Subject: FW: Material objection: Warwick Nurseries Planning Appeal, BN/153/20/PL, 14th April 2021

This email is with reference to the planning appeal for planning application BN/153/20/PL, Warwick Nursery Barnham Road, Eastergate, Barnham PO20 3RT.

Access Drawing / Traffic Calming Measures / Visibility Splays

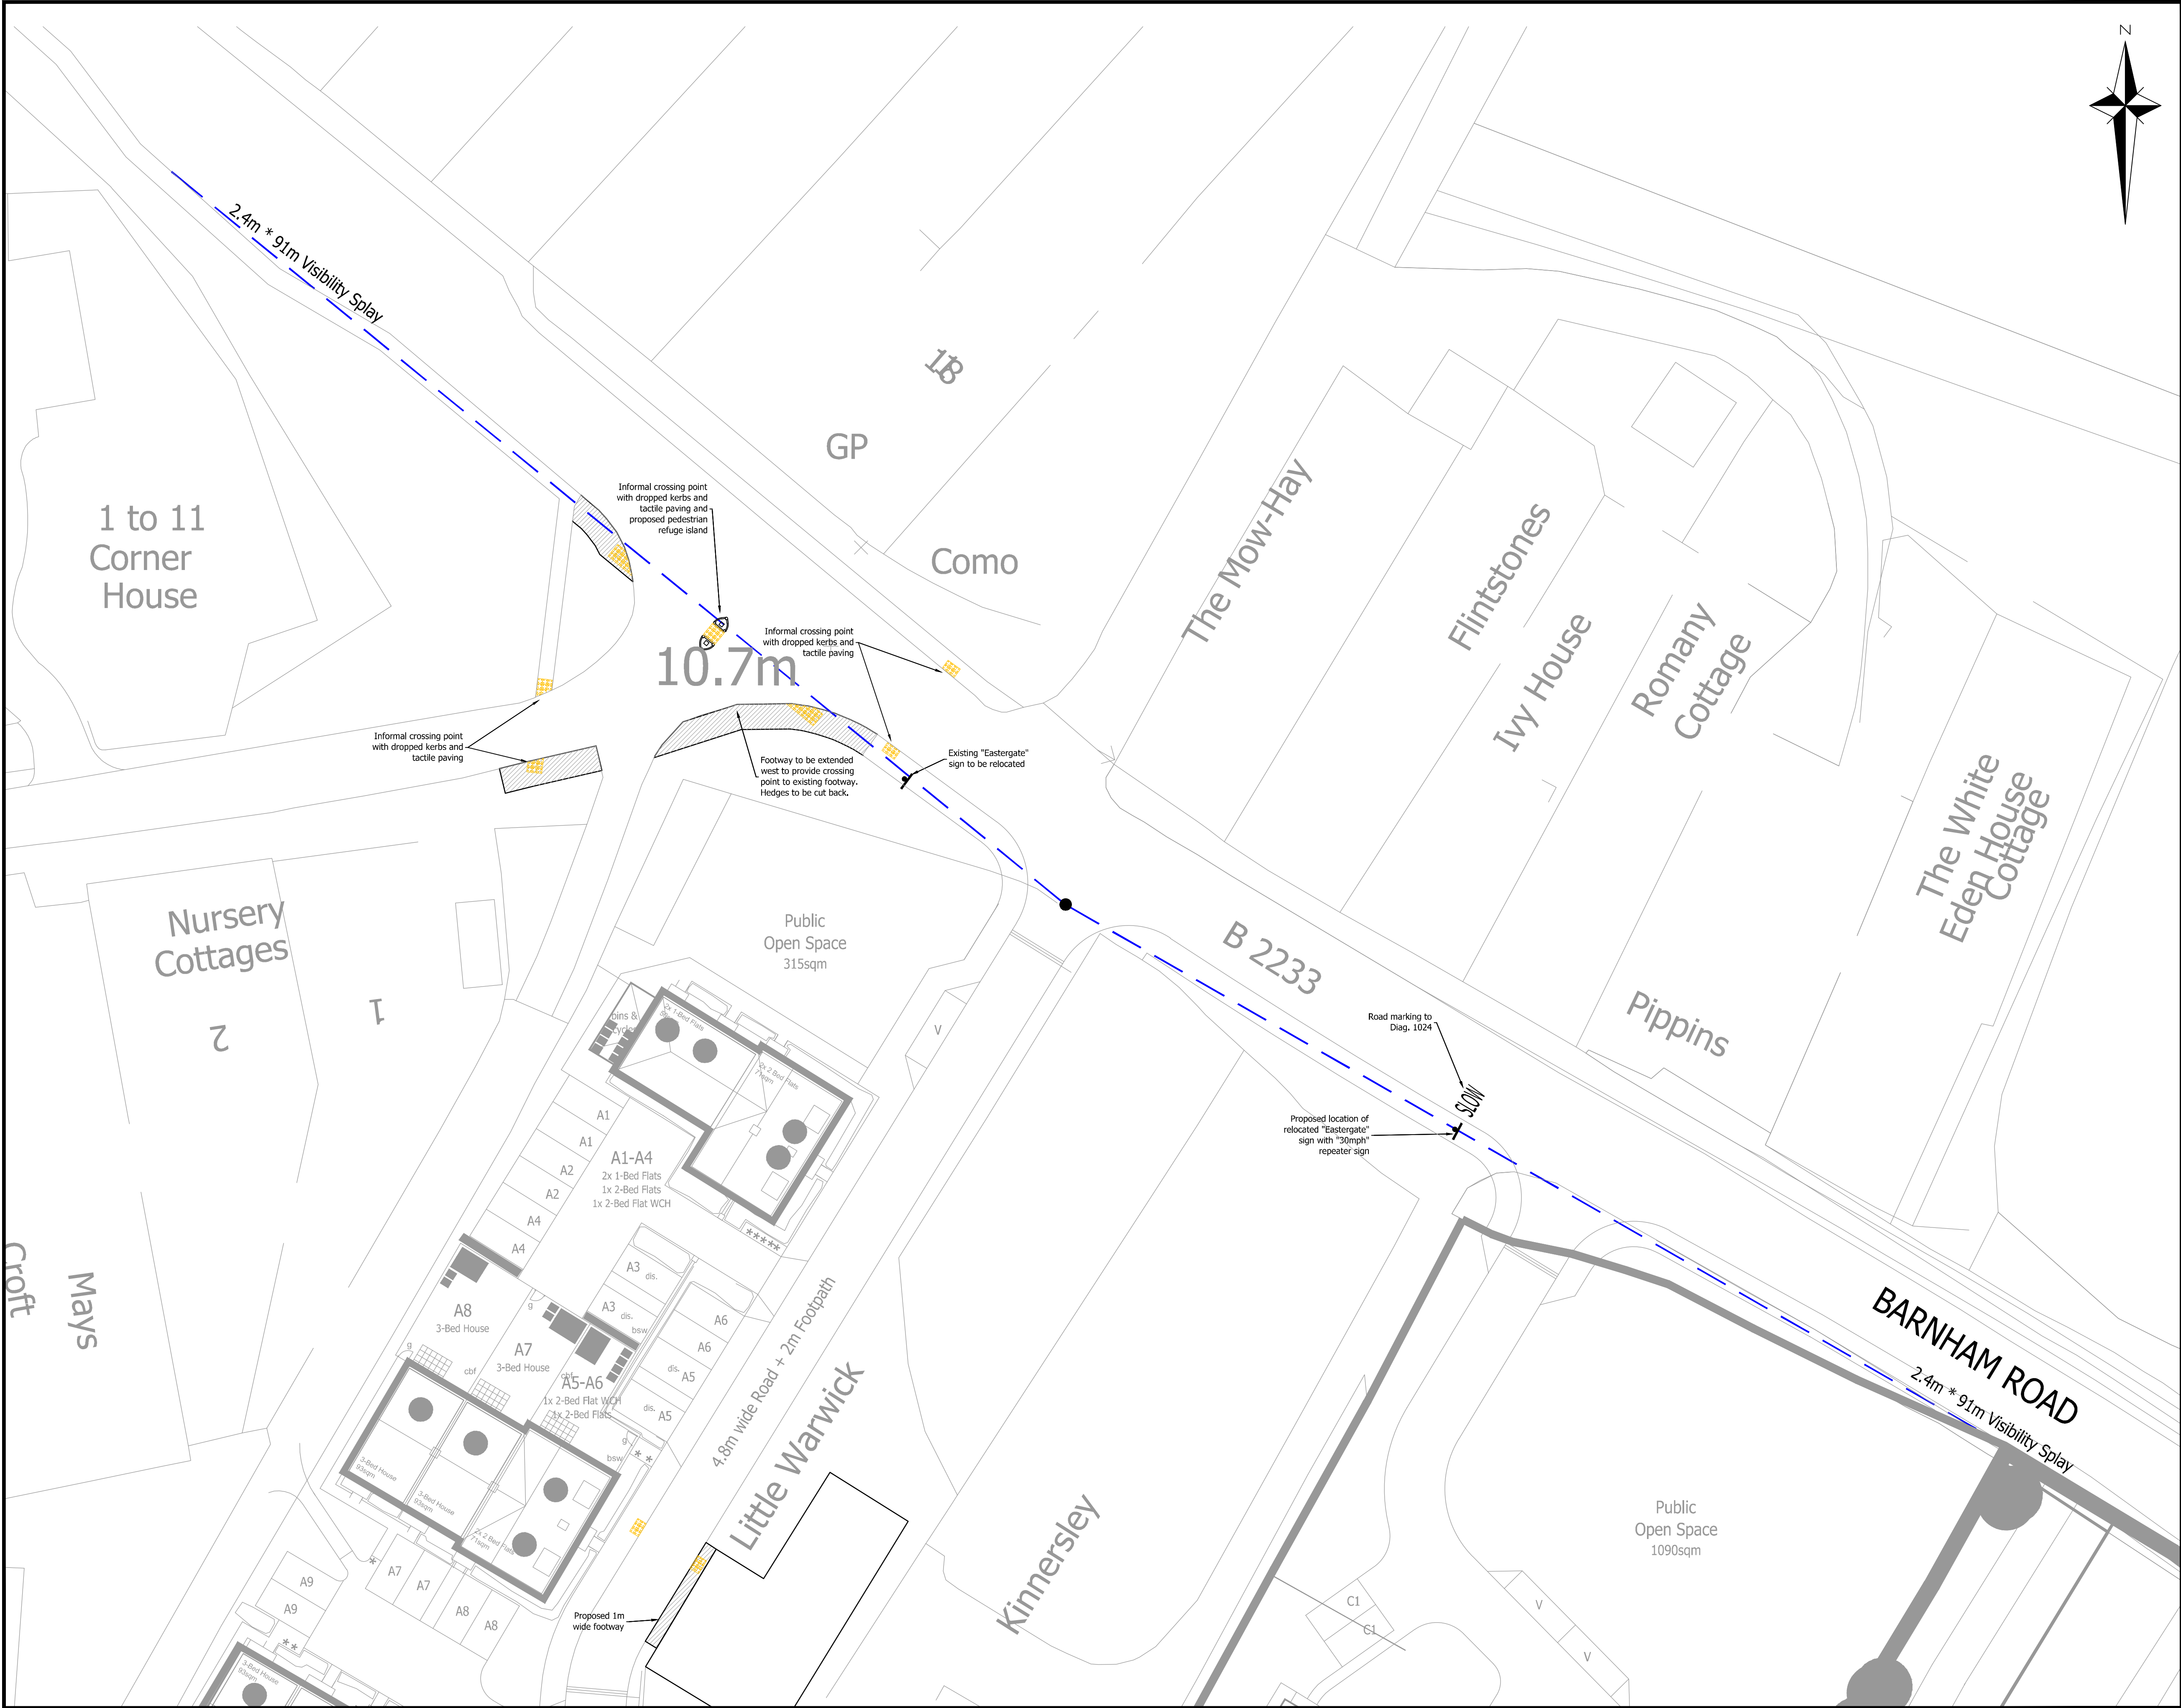
Based on Landacre's submitted design the proposed access splays onto the B2233 Barnham Road appear to cross our land. This has not been discussed or agreed with us (please see Title Deed WSX34601 which is attached). We made Landacre aware of this specific issue at the same time we raised the objection and sent them a copy of our title deed. They have acknowledged they are aware of our objection but we have not seen a revised plan or been engaged in any discussion relating to this point. Nor have we seen a revised splay design on the Arun planning portal.

We understand that in general terms a developer and planning authority do not need to respond to any objection which is raised. However, it cannot be allowable for a plan to be submitted and reviewed if it involves land which is not owned by the developer and where permission to use the land has not been granted by the landowner.
